Recommendation Report for Prior Notification for Householder Extension

REF NO: R/107/18/PDH

LOCATION: 23 Preston Avenue
Rustington
BN16 2DF

PROPOSAL: Notification under extended permitted development rights for a single storey rear extension extending 6.5m from the rear of the original dwelling house, with a maximum height of 2.85m & an eaves height of 2.85m.

23 Preston Avenue, Rustington, Littlehampton, BN16 2DF	Existing Floor Plan, Roof Plan and Sections	
	June 2018. Drawn by The Pure Group	
	Scaled at 1:50 / 1:25 on A2	
Drawing Reference: PA.EX.PLAN/SEC.001

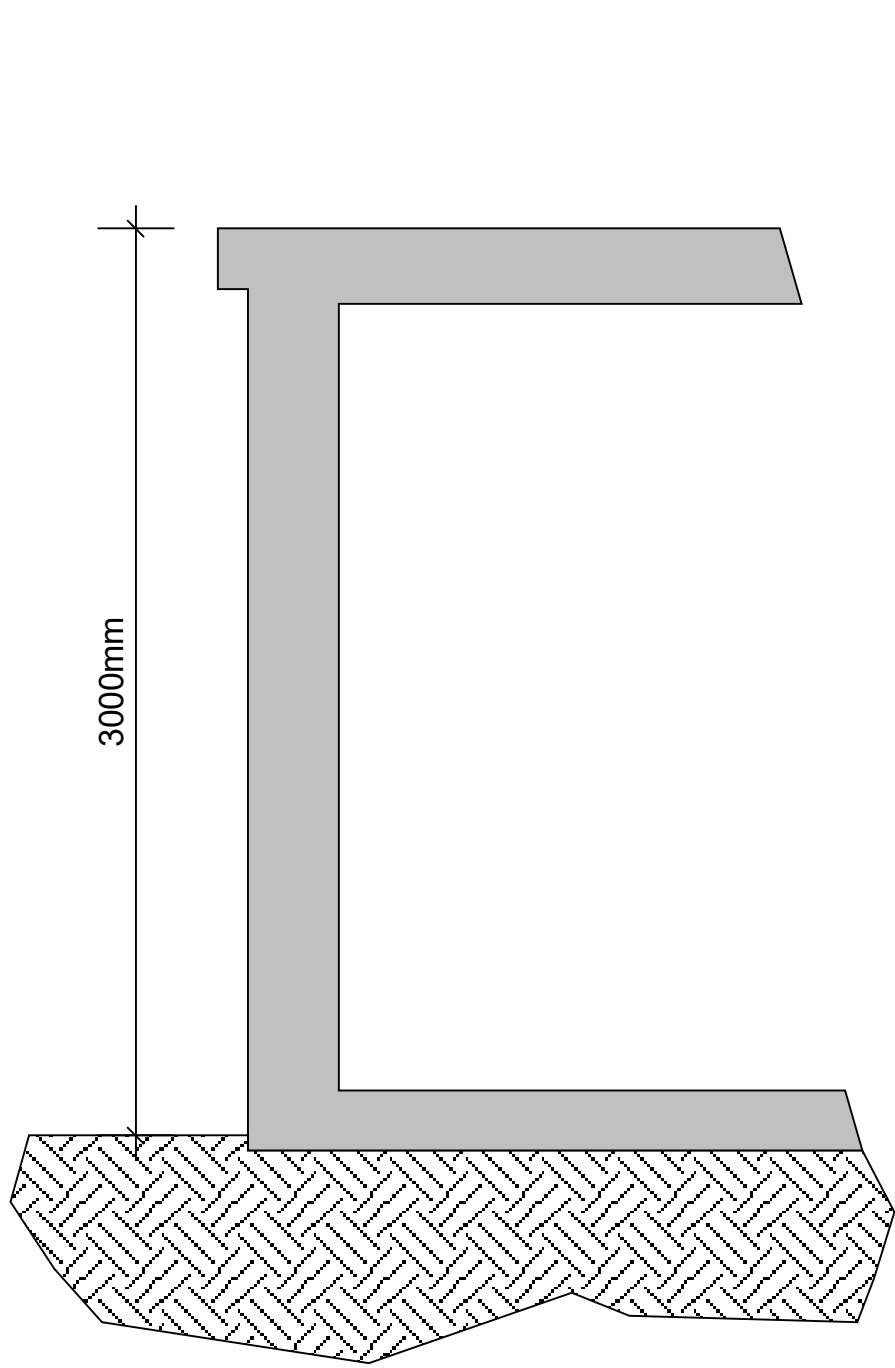
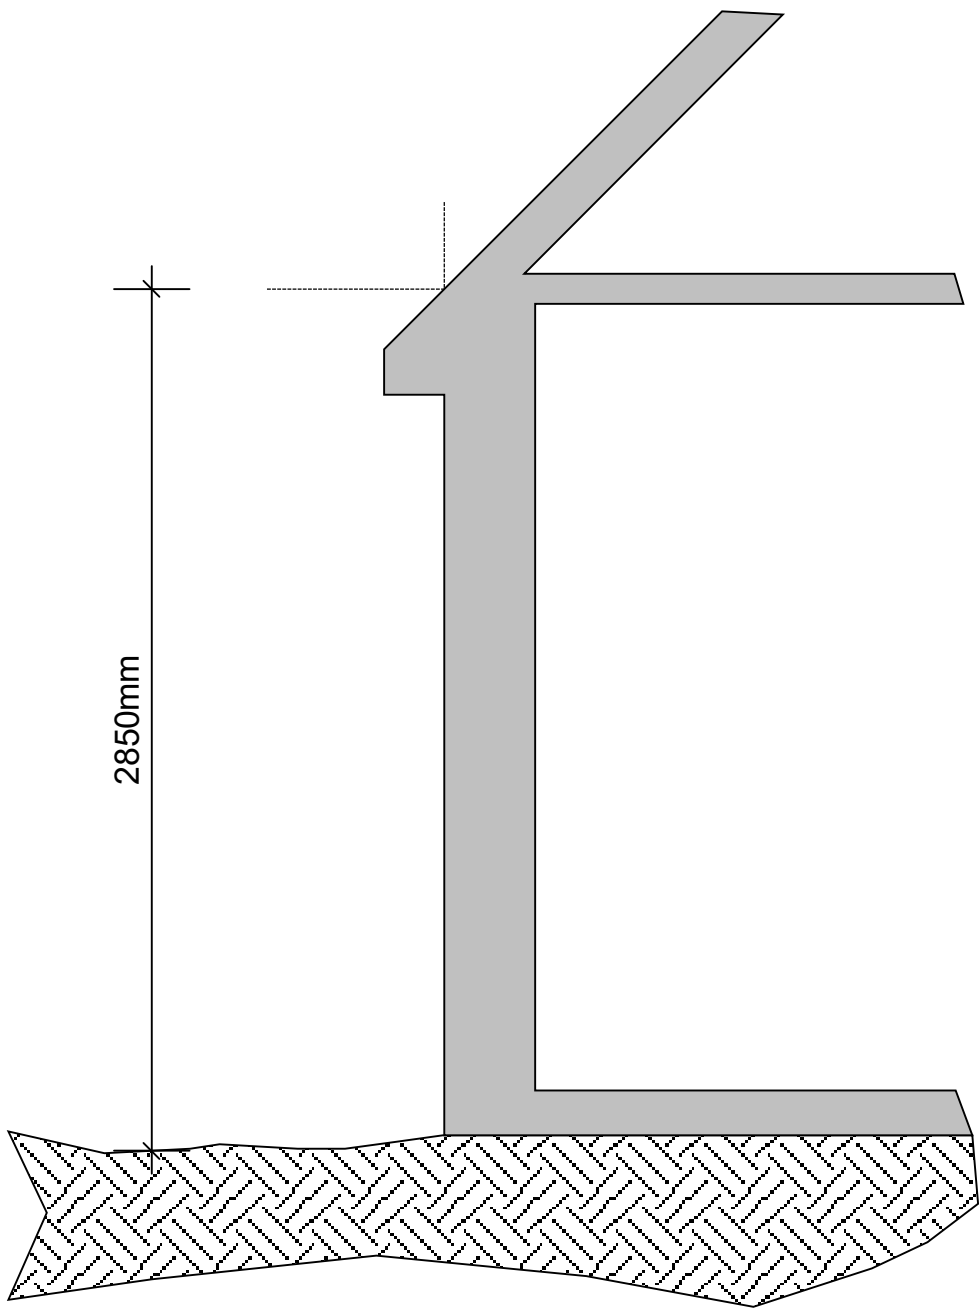
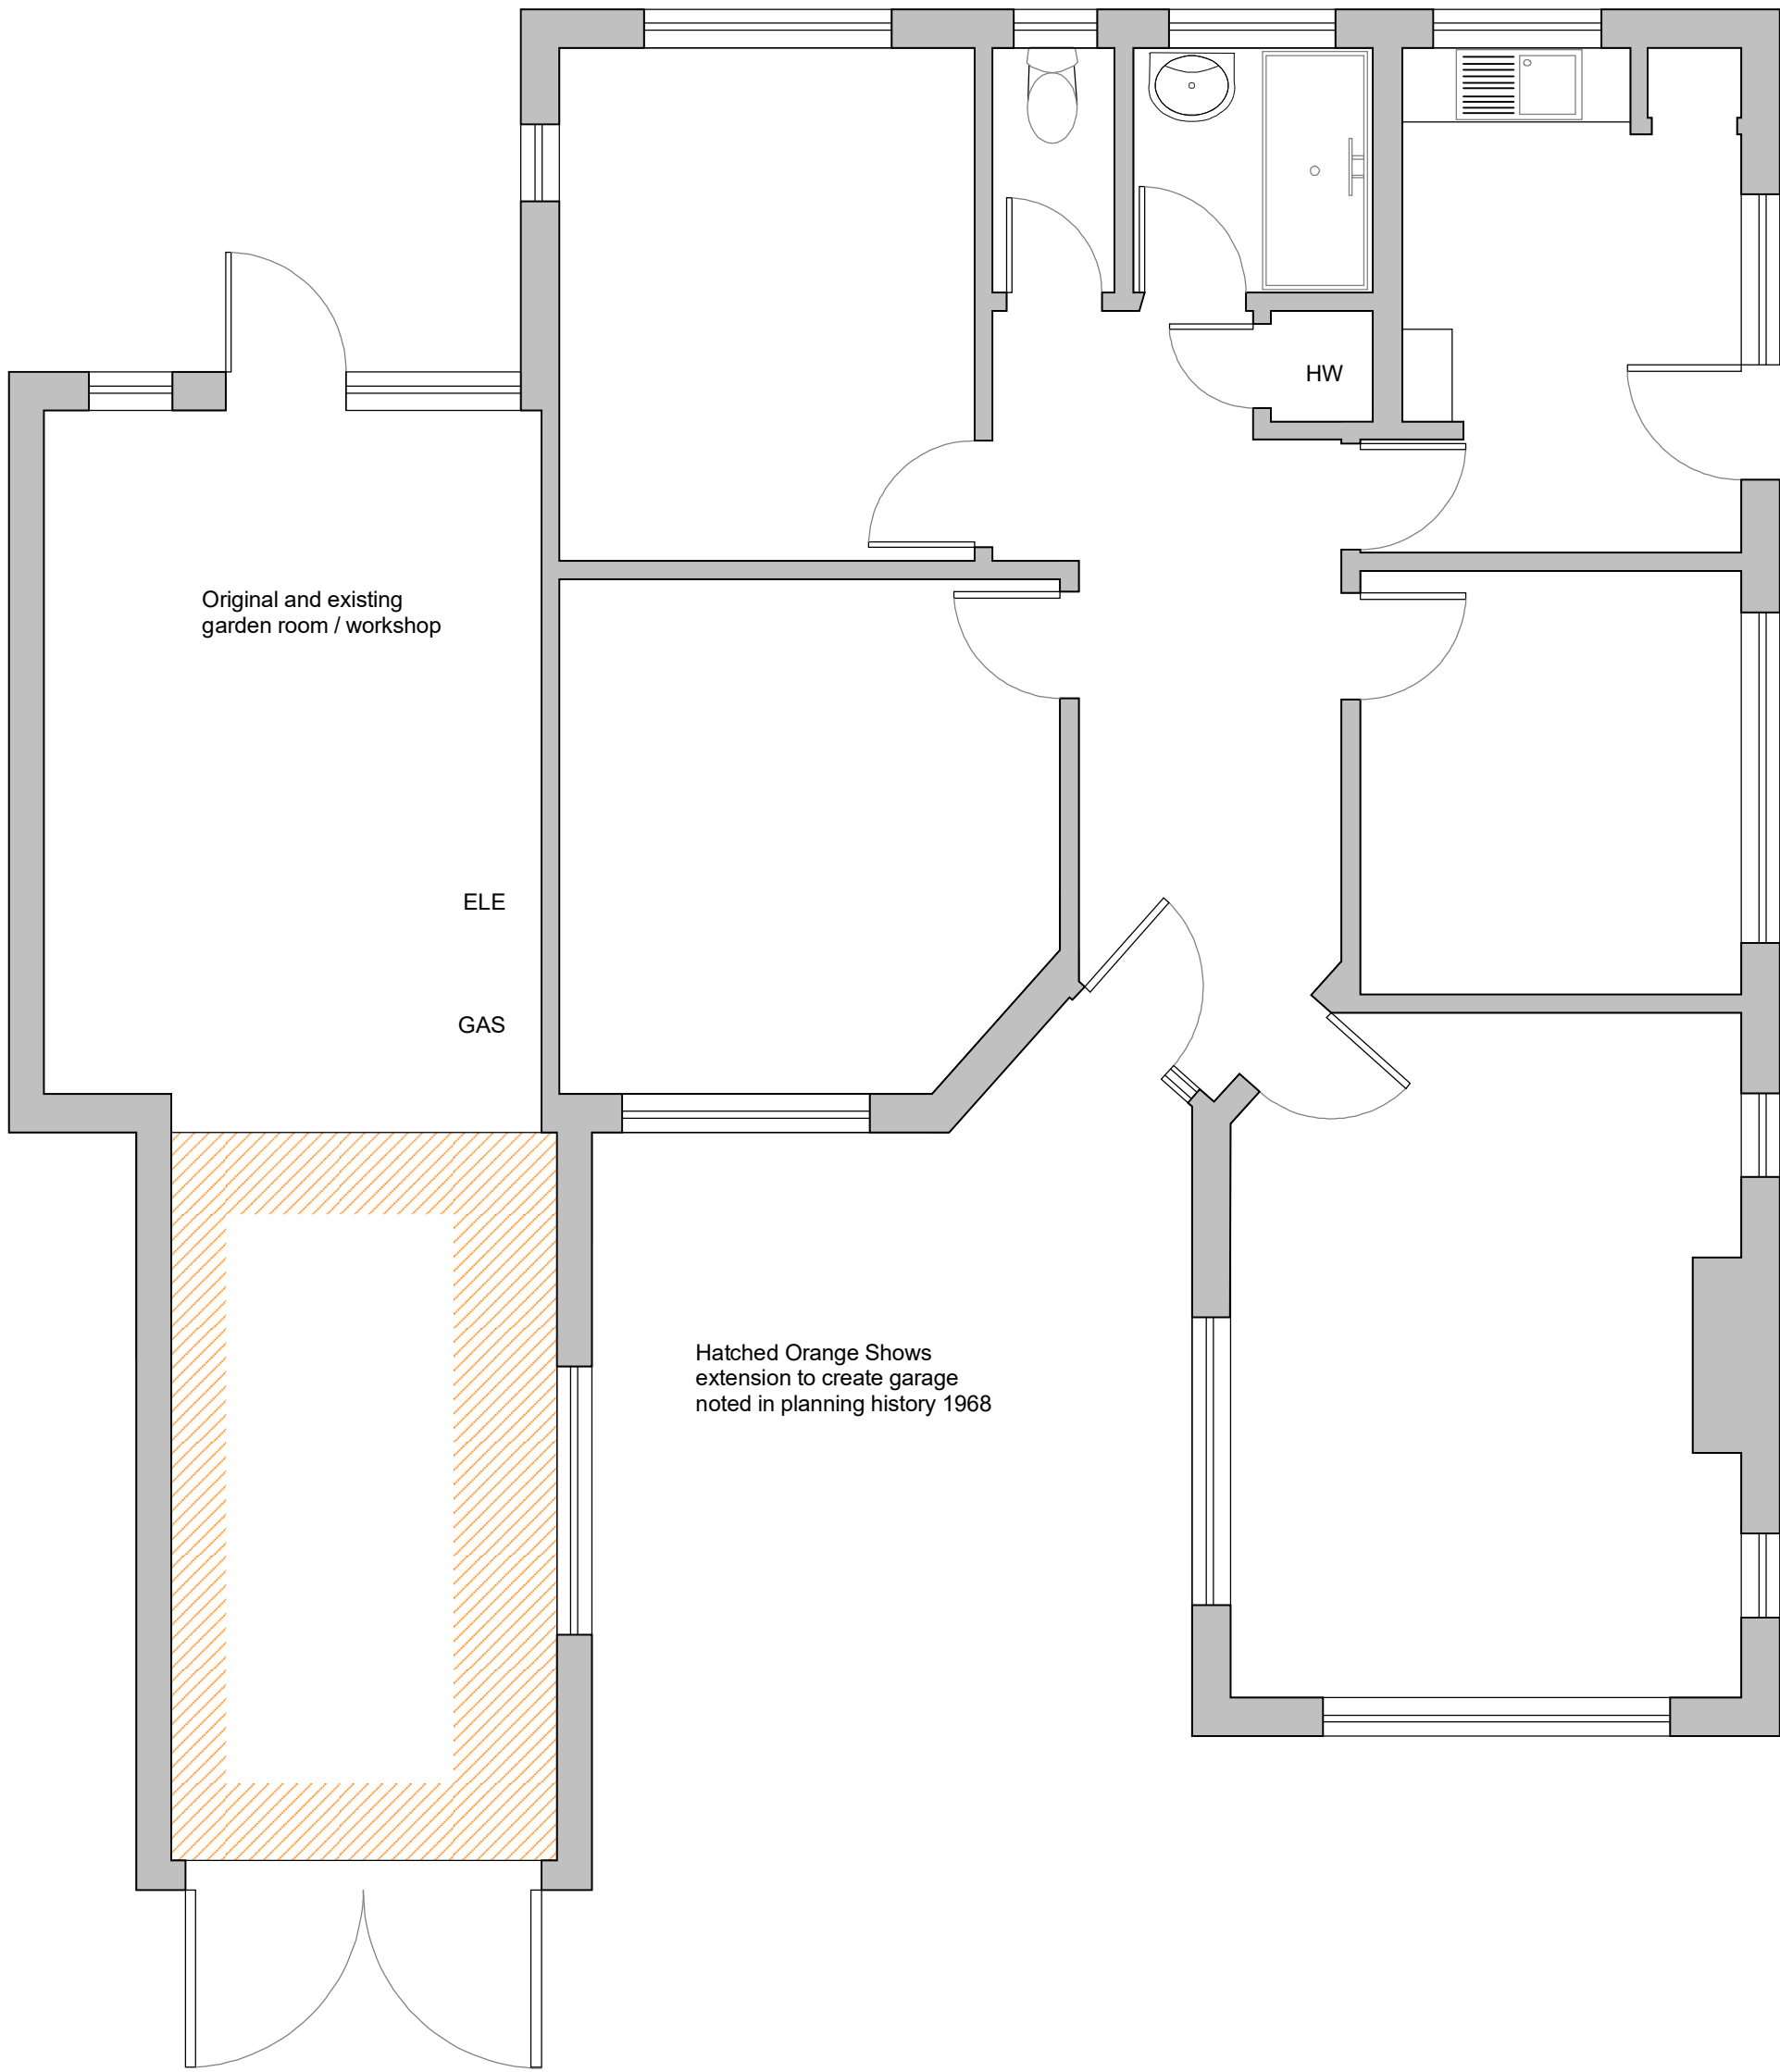
- Extension is too high and too close to the boundary
- Doesn't comply with legislation in that the height is higher than the eaves height.
- Doesn't comply with legislation in that the roof height would mean alterations to link to the existing roof
- Roof lanterns would increase adverse visual impacts
- Out of character with other properties
- Block plan is misleading
- Room should be allowed for maintenance to boundaries walls.
- Depth of the property will increase by 50%
- Lack of natural ventilation means vapours/ odours from the kitchen will vent to neighbouring properties
- Re-configuration of the internal dwelling will be different to neighbouring properties

Confirmation of eaves height and total height of the proposed development were requested and additional plans were submitted. For clarification the eaves height is measured from the base of the external wall of the extension to the point where the external wall would meet the upper surface of roof slope.

The proposed extension will measure a maximum of 6.5 m depth. The proposed eaves height and total height will be 2.85m to match that of the existing dwelling.

The proposed extension will be constructed to a height of 2.85m and will match that of the existing dwelling as shown in the approved plan and will be constructed with a flat roof. It should be noted that a structure can be constructed under Permitted Development to a height of 4m without the need for a formal planning application. In addition the presence of hedging of sufficient height will mean that there will not be an unacceptably adverse overbearing impacts upon the neighbouring property at No.7 or other adjoining neighbours. The proposal is also for this reason not considered to give rise to any loss of privacy due to outlook or any loss of light.
